JUDGE ORR RANCHETTES

PRELIMINARY PLAN

EL PASO COUNTY, COLORADO

JUDGE ORR
RANCHETTES
PRELIMINARY PLAN

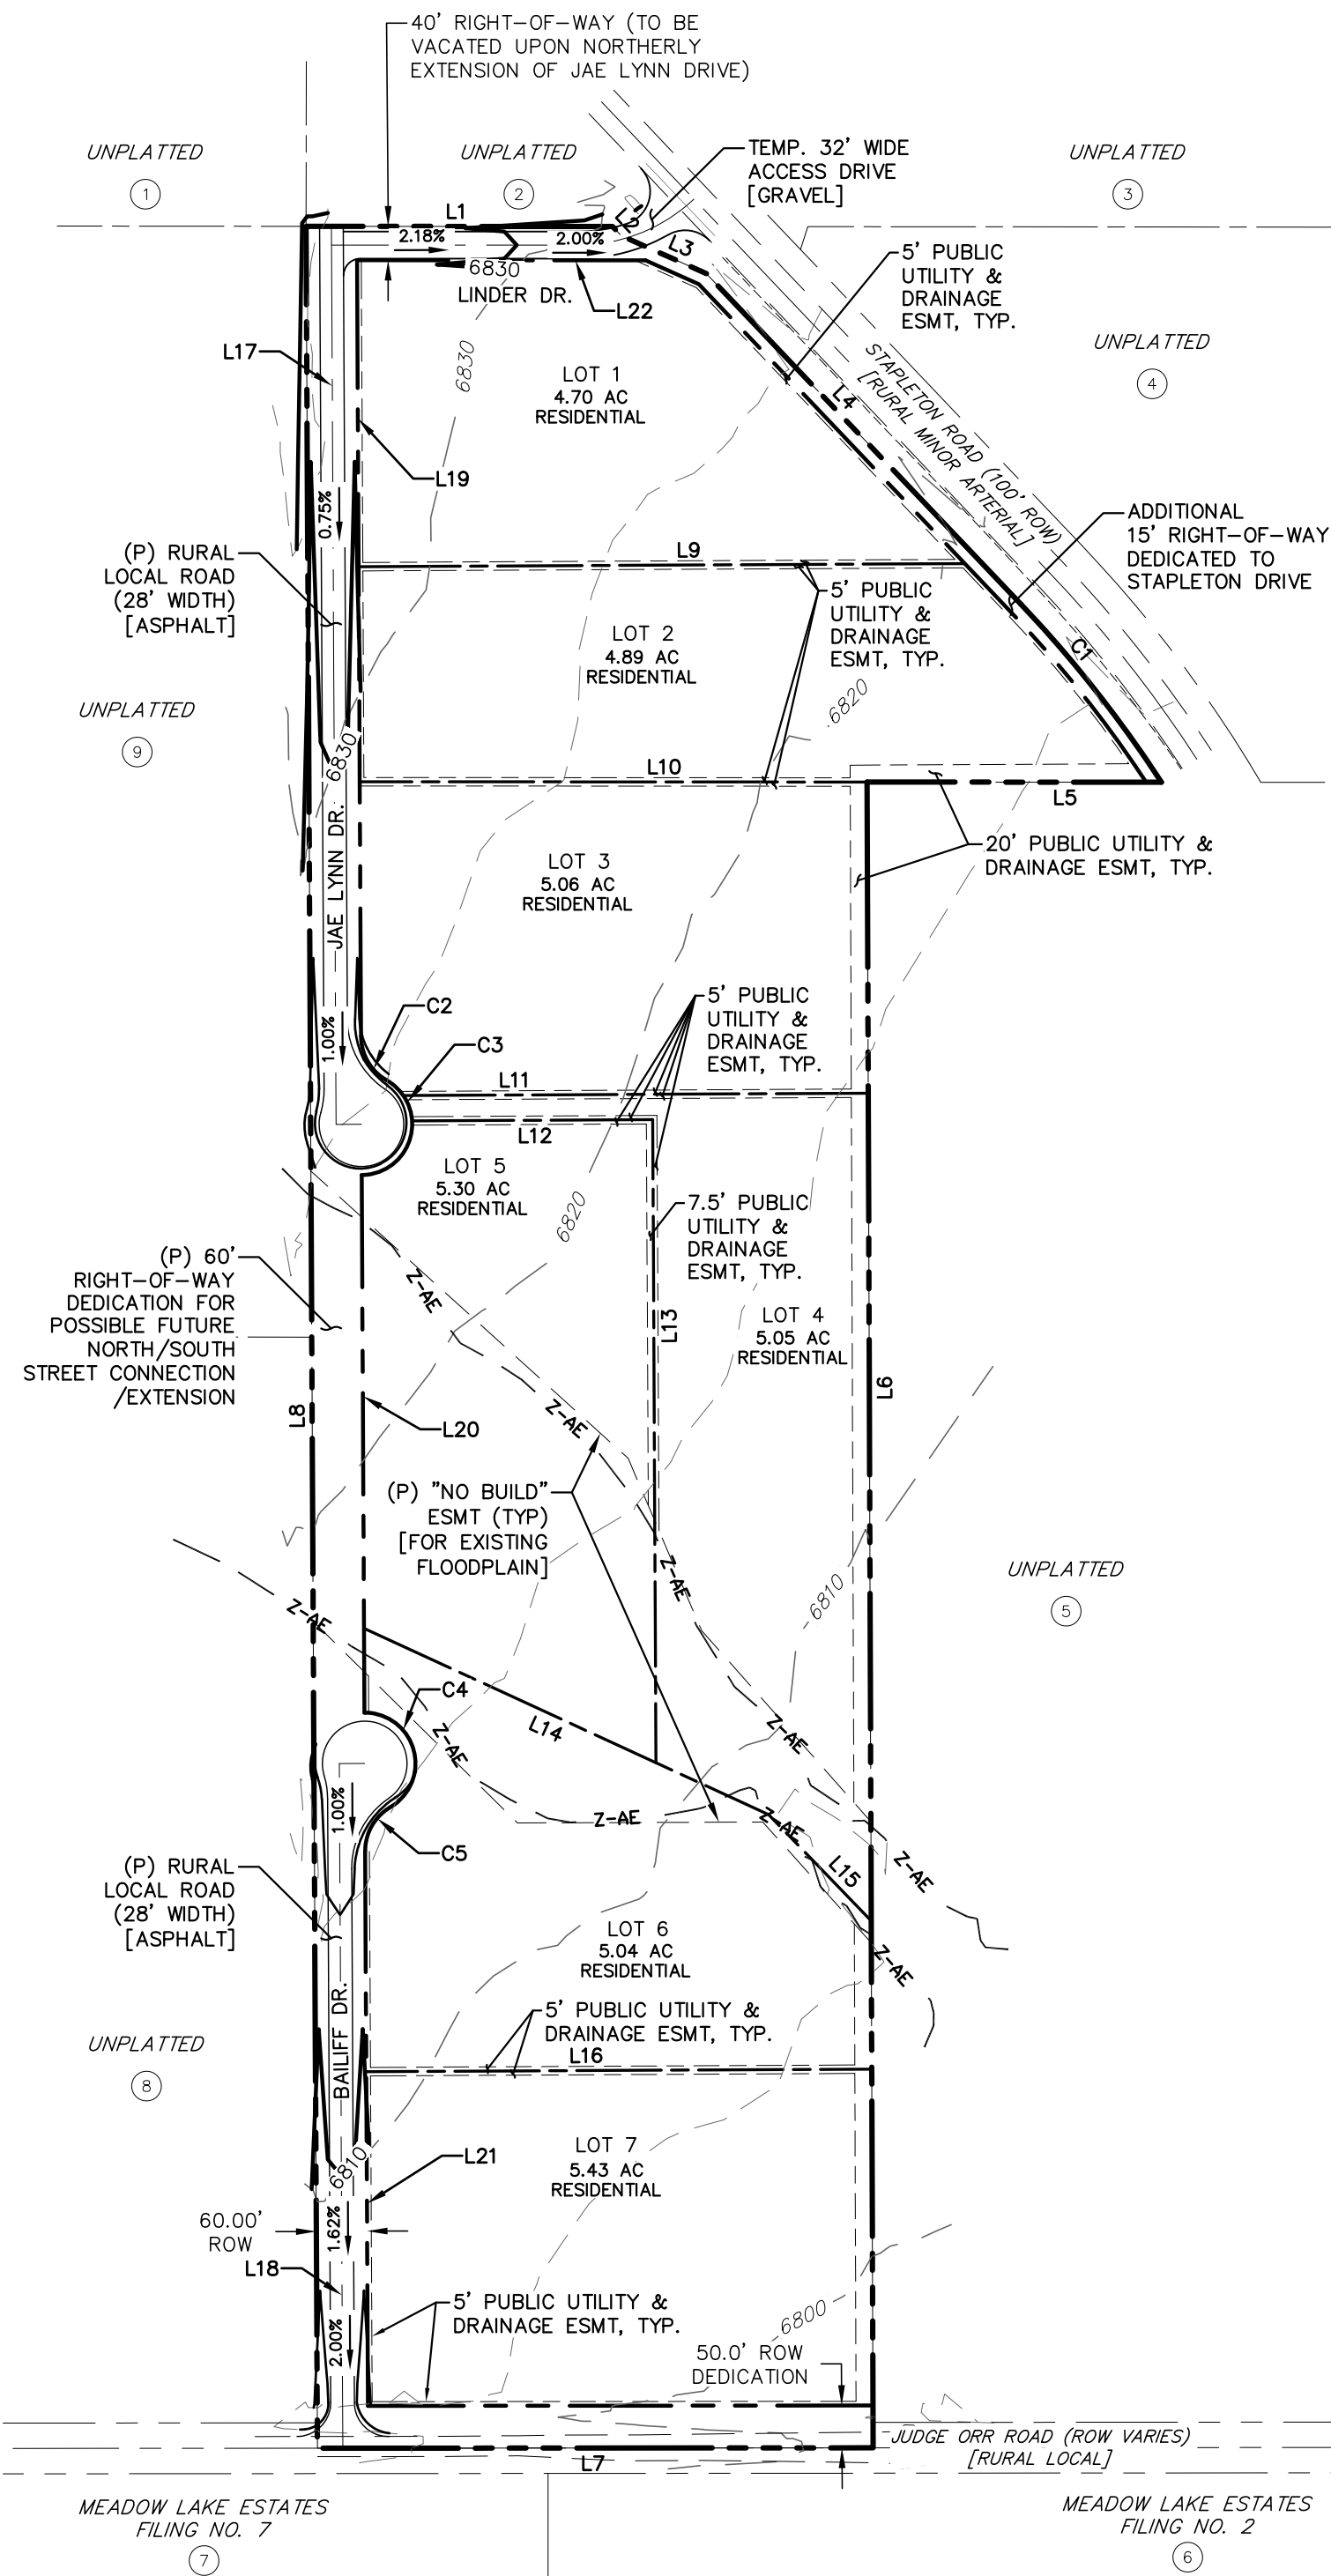
Add section, township, range

Add notes for services, fees to be paid (park, school, drainage, traffic). If building sites have been determined, please add.

please relocate indicator so it cannot be confused with the floodplain

Add net acreage calculations for lots impacted by no build.

indicate ROW dedication width

there are two property lines here
